BR/282/19/PL

The Beach Hotel, former Mud Club & 2-4 Waterloo Square Bognor Regis PO21 1SU

Redevelopment into 35 No. 1 & 2 bed apartments and 3 No. commercial units (A1 Retail or A3 Restaurant/Cafe). This application affects the character & appearance of The Steyne, Bognor Regis Conservation Area & may affect the setting of a listed building.

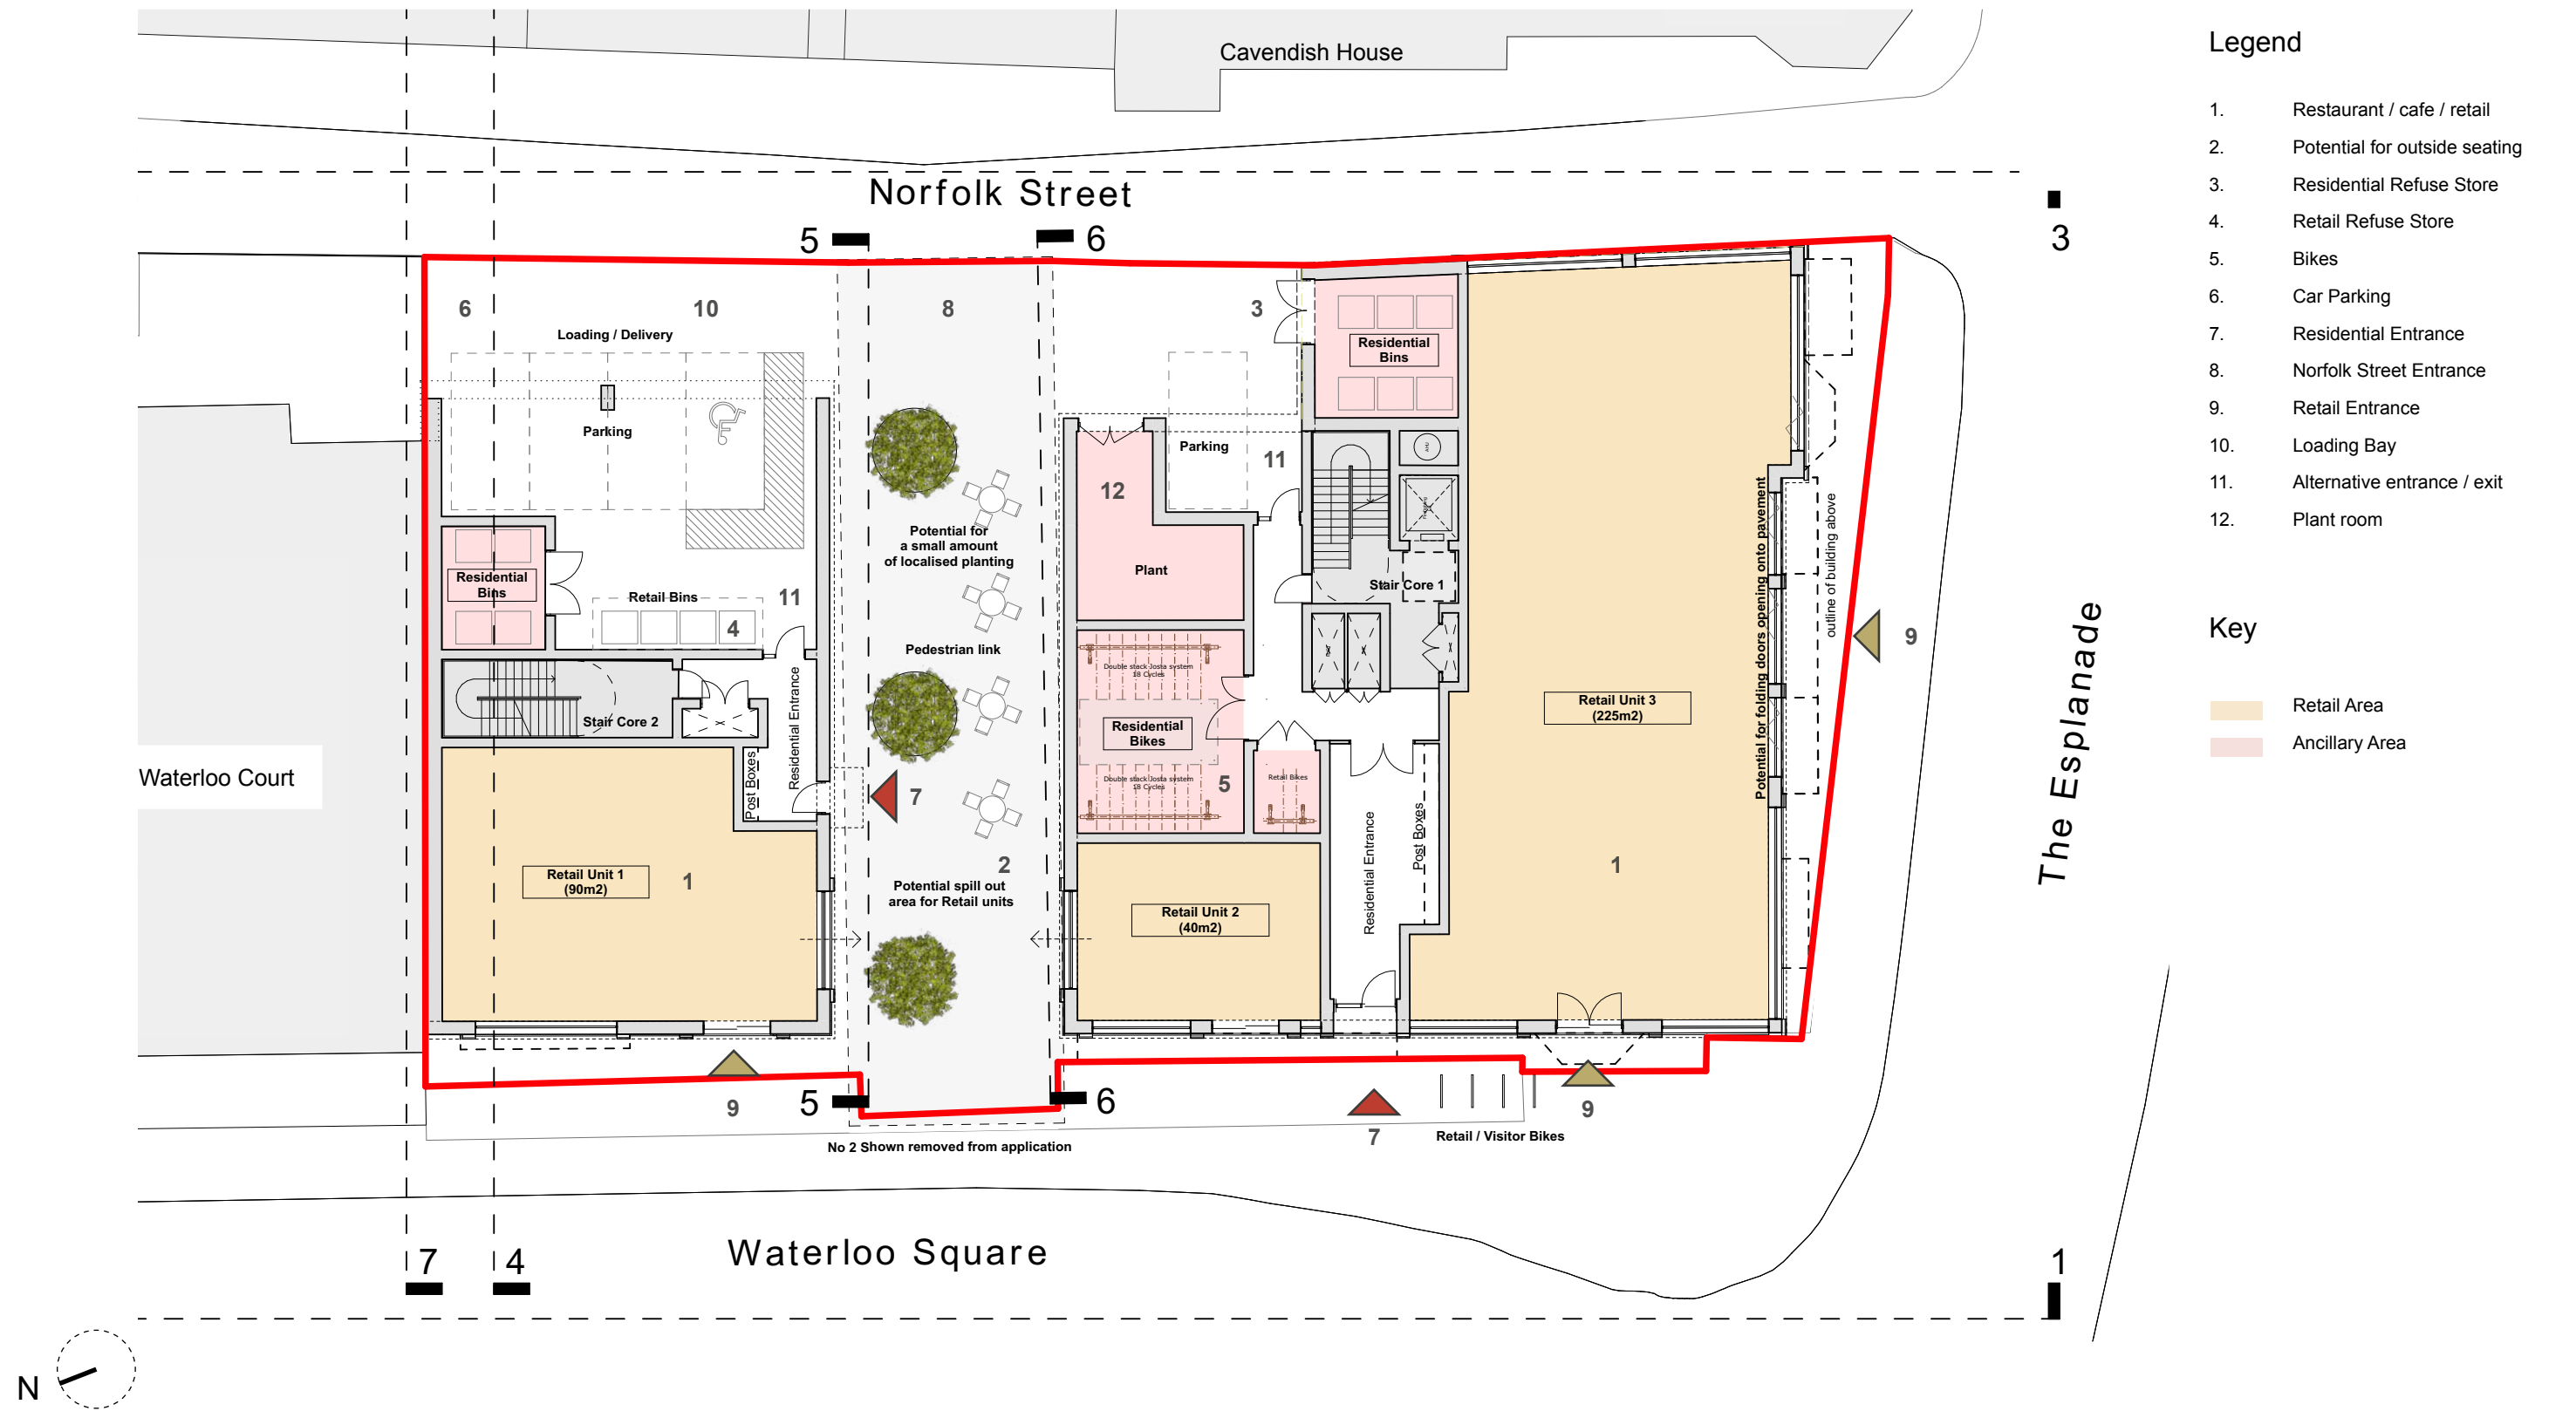
However, there are still problems with the revised plans. It is not clear why the site has been divided up in to two blocks of development. Such a proposal removes the continuous line of development along the side of the square, which is a notable feature.

Further, the proposed buildings are still of a scale and massing which is considered to be out of character with the surrounding buildings/area. They appear to be approximately 50% higher than neighbouring buildings on both sides; five proposed floors alongside three existing on the Waterloo Square elevation and six floors against the four already present on The Esplanade. As previously identified, this is a significant issue when viewed in the context of the square which causes harm. There is also an unsatisfactory relationship between the (northern) building and the neighbouring Waterloo Court which remains.

Elevations 4 and 6 are predominantly blank facades – these elevations front on to the ‘open space’ area between the two buildings. Such an element creates an almost blind corridor through the site. Whilst the reason for this may well be related to the issue of privacy, it is thought that these blank elevations will be visible from at least Waterloo Square, which is out of character.

With regard to materials, it is not clear why the intention is for the elevations to be ‘white brick’. It is not clear what this material choice was based upon, how it would weather in this location or what the mortar joints will also look like.
